Appeal Decision

Appeal Ref: APP/R5510/D/21/3286839

1 Bury Avenue, Ruislip HA4 7RT

- The appeal is made under section 78 of the Town and Country Planning Act 1990 against refusal to grant planning permission.
- The appeal is made by Mr & Mrs D Riggal against the Council of the London Borough of Hillingdon.
- The application Ref 24235/APP/2021/2038, dated 9 May 2021, was refused by notice dated 27 August 2021.
- The development proposed part single storey, part two storey side/rear extension (including extension over existing front garage), alterations to roof of existing two storey side element and conversion of roofspace into habitable use to include a rear dormer.

02A

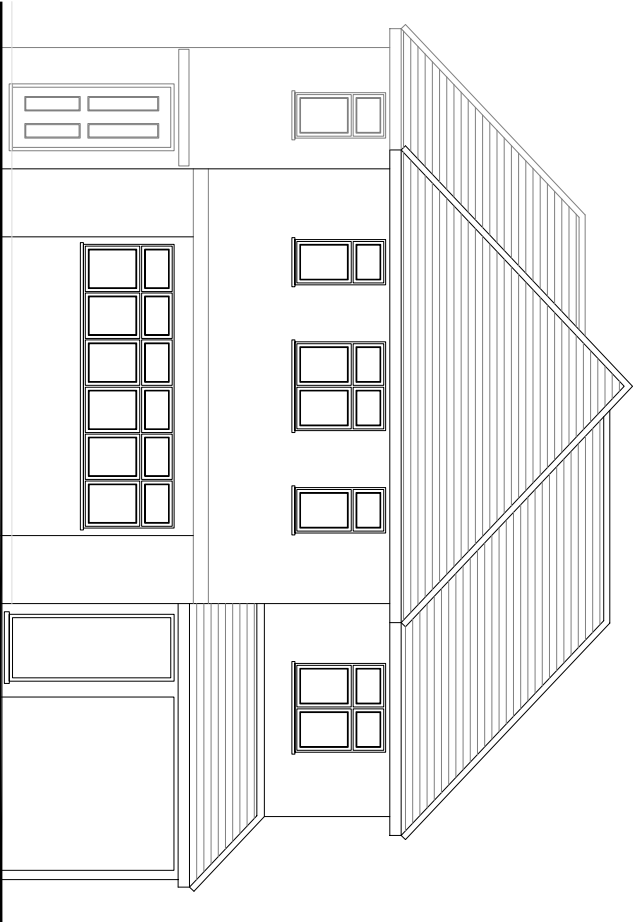
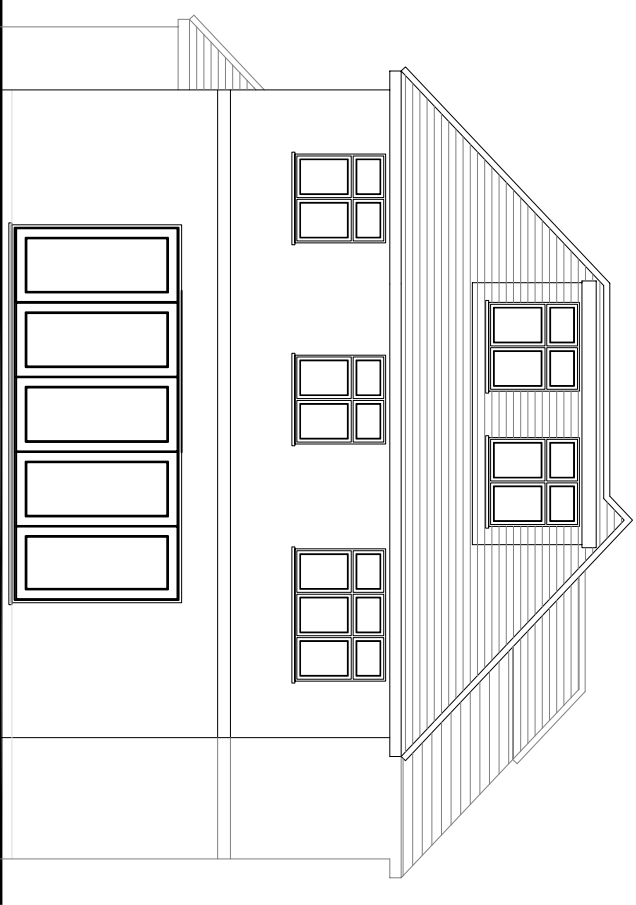
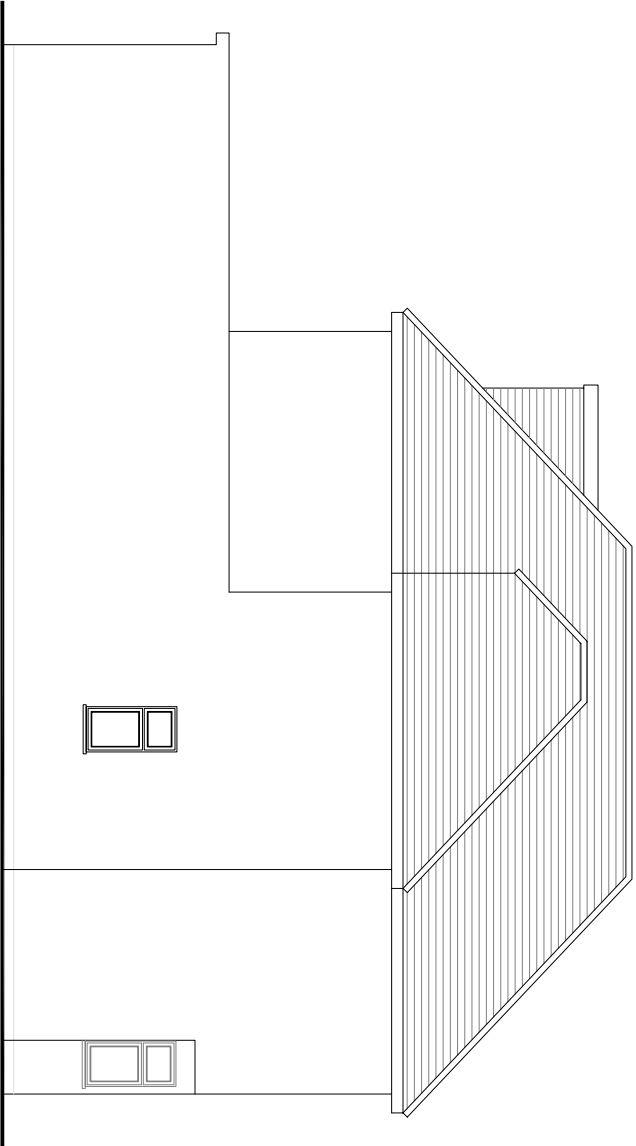
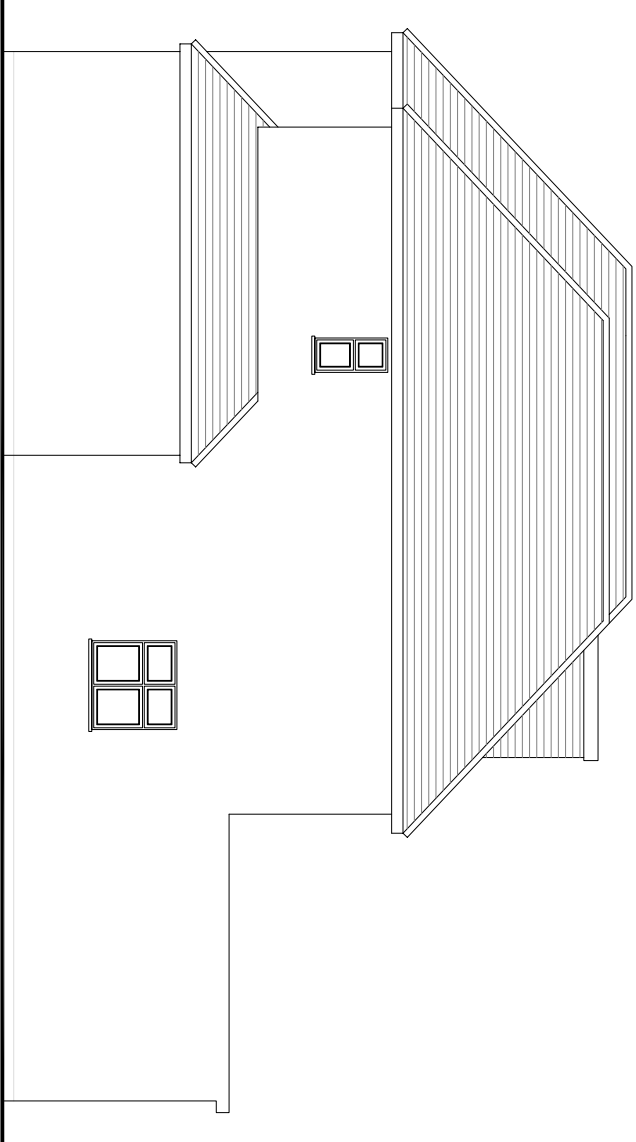
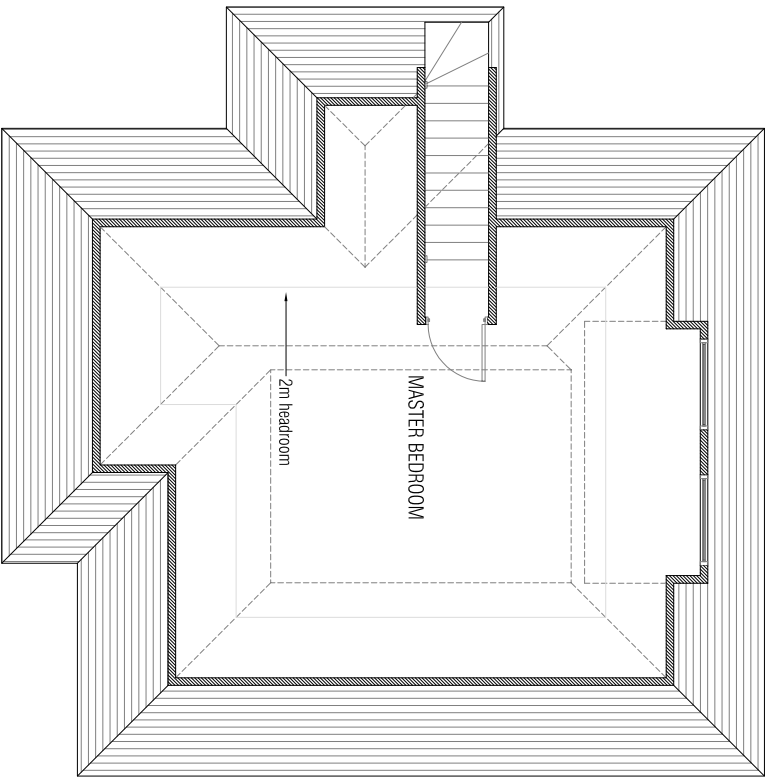
6. The proposed two storey development would introduce a first floor to the side of the garage with the first floor set back from the existing main front elevation, including a canopied element and front access to the garage area to the ground floor. The side extension would provide an additional bedroom to the first floor, and introduce an extension of the roof including a double dormer window element to the rear elevation, making use of a 'crown roof' addition. The resultant development would have varied ridgelines, with the height and form of the original hipped roof being retained, and the new elements, lower than and being set back from the front elevation.

8. Policy DMHD 1 sets out a requirement that roof extensions should not create a dominant 'top heavy' appearance out of proportion with the rest of the building. Whilst the extensions proposed are sizeable, the design takes cues from the existing dwelling and respect the original dwelling and the existing hipped roof would remain largely apparent as seen from the street. The crown roof extension would allow the original building to retain its character and appearance, whilst enabling the extension of the property.

9. The dormer window would be located to the rear, would be subservient to the scale of the existing roof and would be located below the ridge tiles of the original roof, and retain a substantial element of the original roof slope above the eaves line. Whilst the Council has concerns that the proposed dormer window would be larger than two thirds of the average width of the original roof, I have also taken into account that the proposed development would

include the extension of the roof, thus extending the average width of the roof. The dormer window would appear proportionate to the roof slope as set out in the plans before me. Therefore, the proposed extensions would comply with the requirements of Policy DMHD 1.
